Your Ref: 2023/92490
Our Ref: Z004563

21st September 2023

Former Dowker Works, Dowker Street, Milnsbridge, Huddersfield, HD3 4JX - Erection of 38 dwellings with associated access and landscaping (within a Conservation Area)

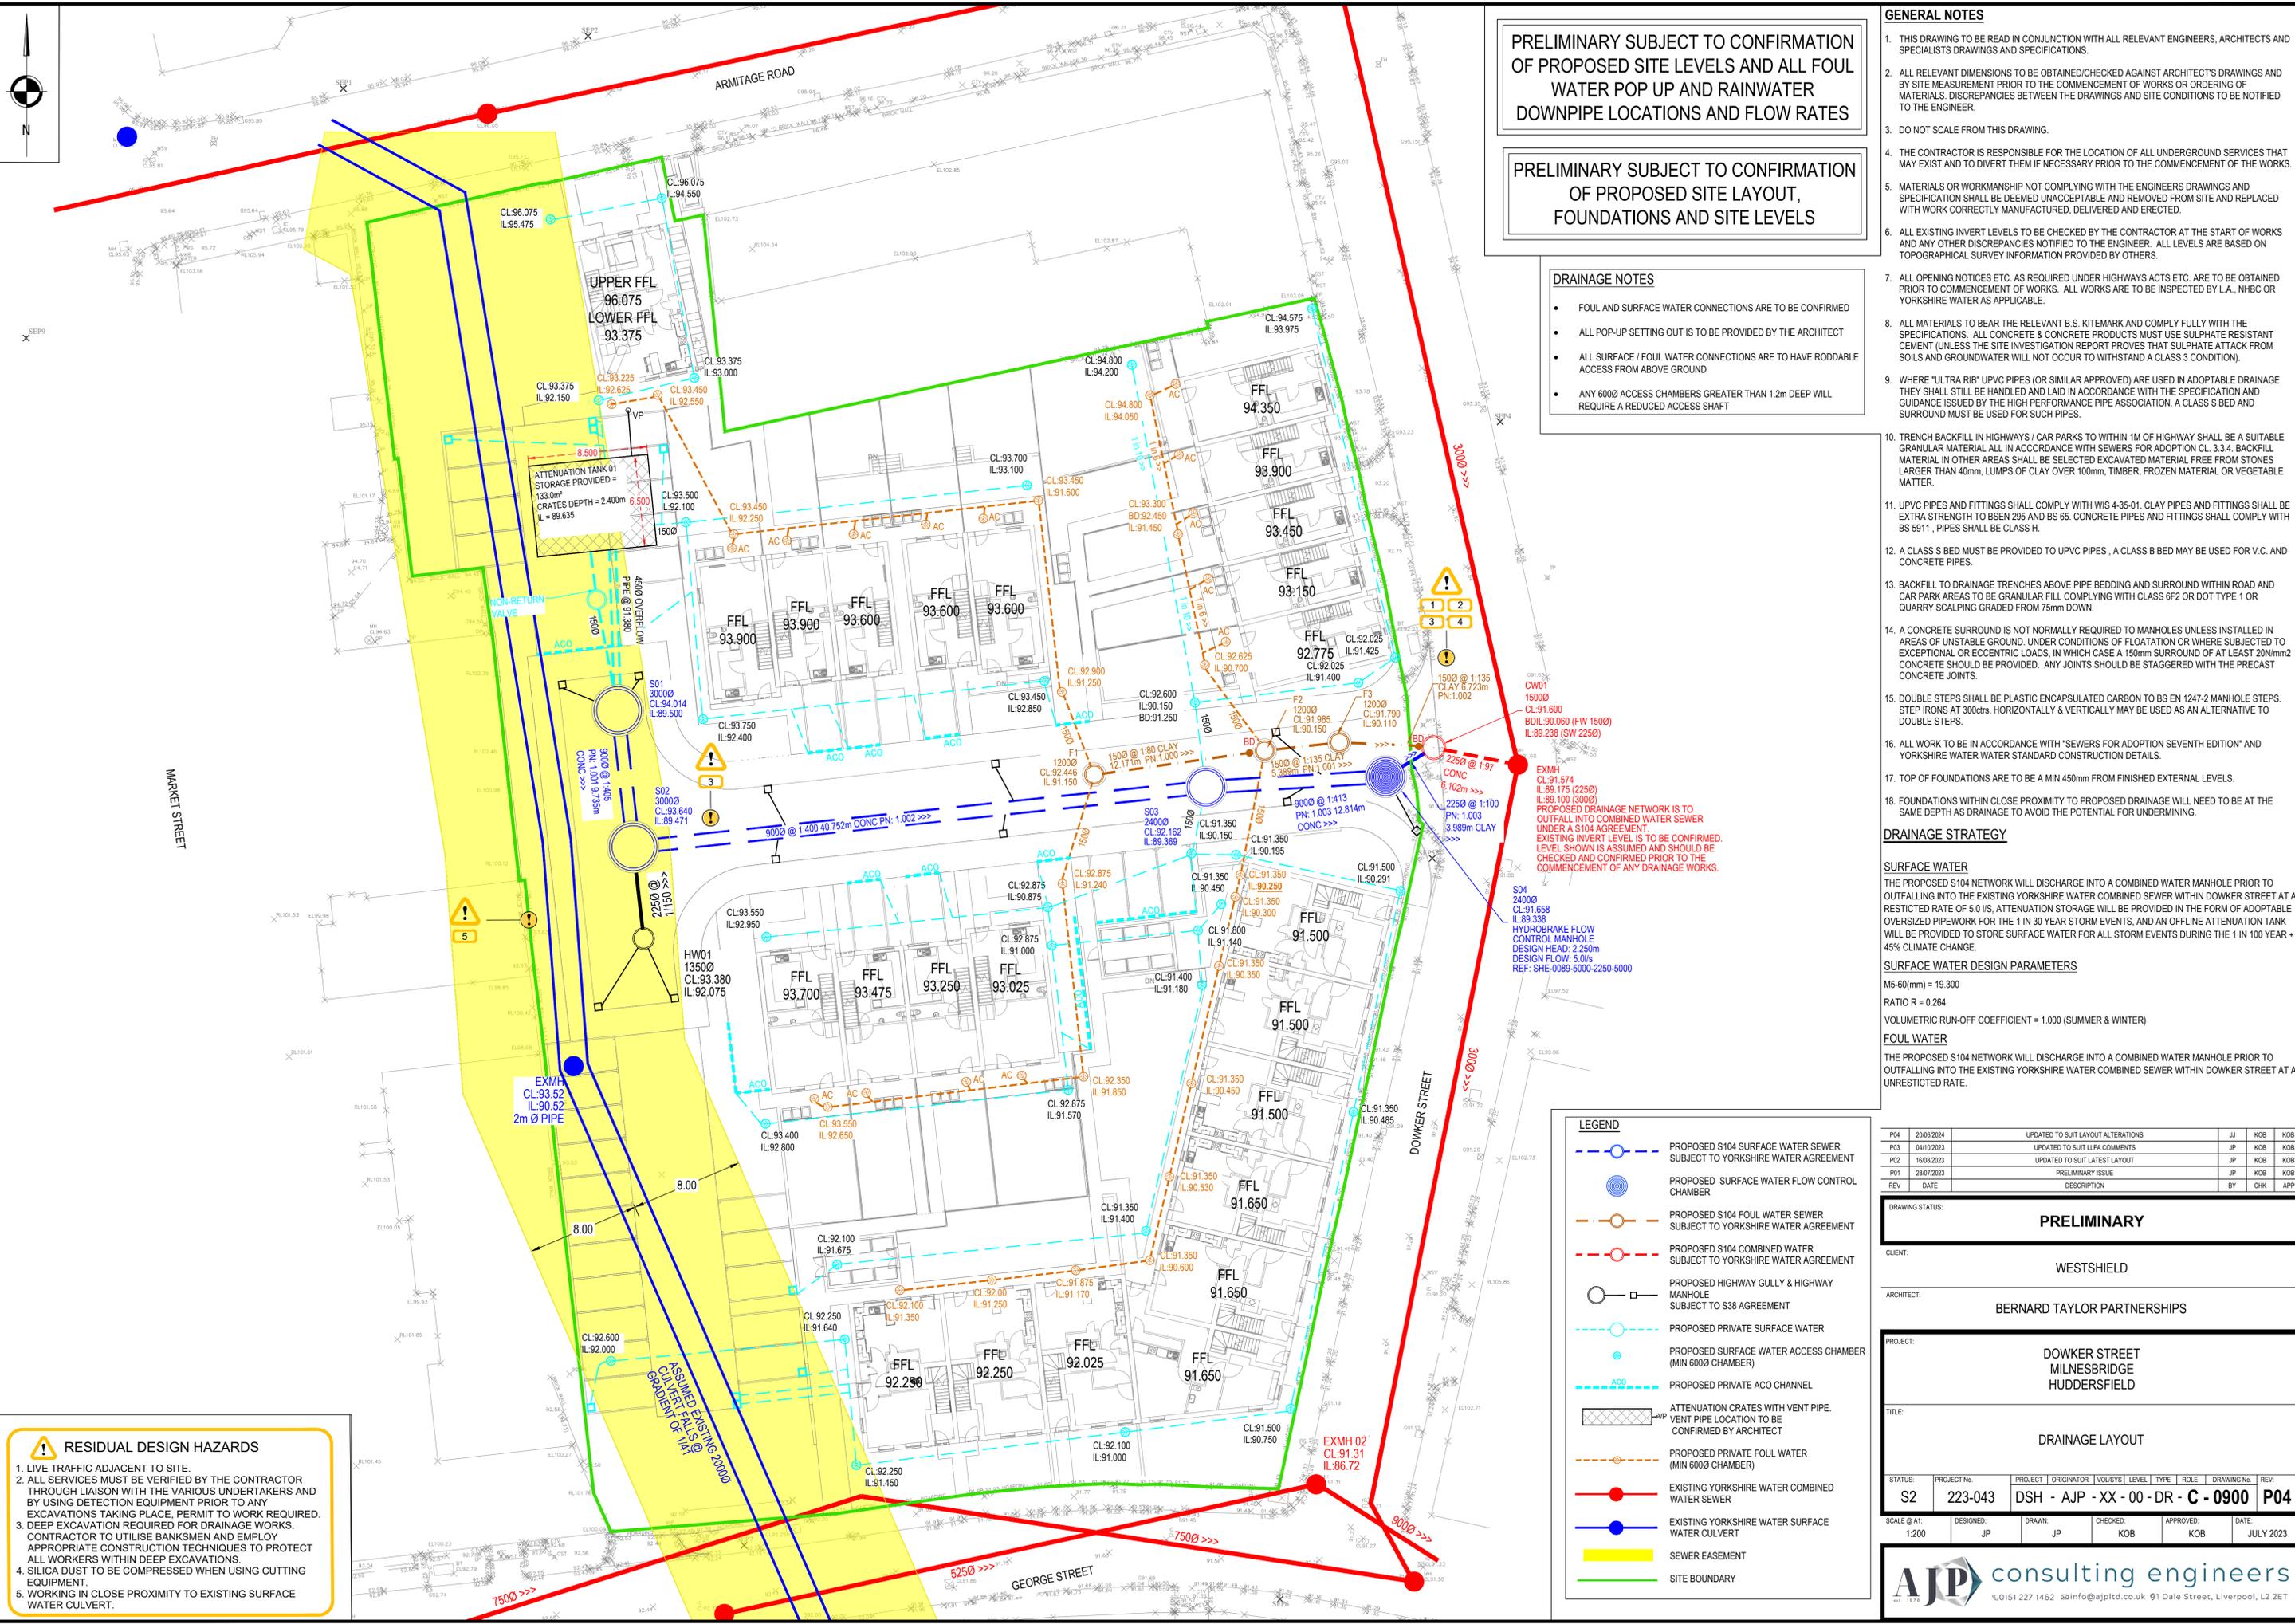
2.) The drainage details submitted on drawing 'Drainage Layout' S2 223-043 (revision P02) dated 16/08/2023 that has been prepared by AJP require amendments, but if planning permission is granted, the matter can be dealt with via condition. The following point(s) should be addressed:

a.) the submitted drawing appears to show a culverted watercourse under the ownership of Yorkshire Water - Yorkshire Water does not own culverted watercourses.
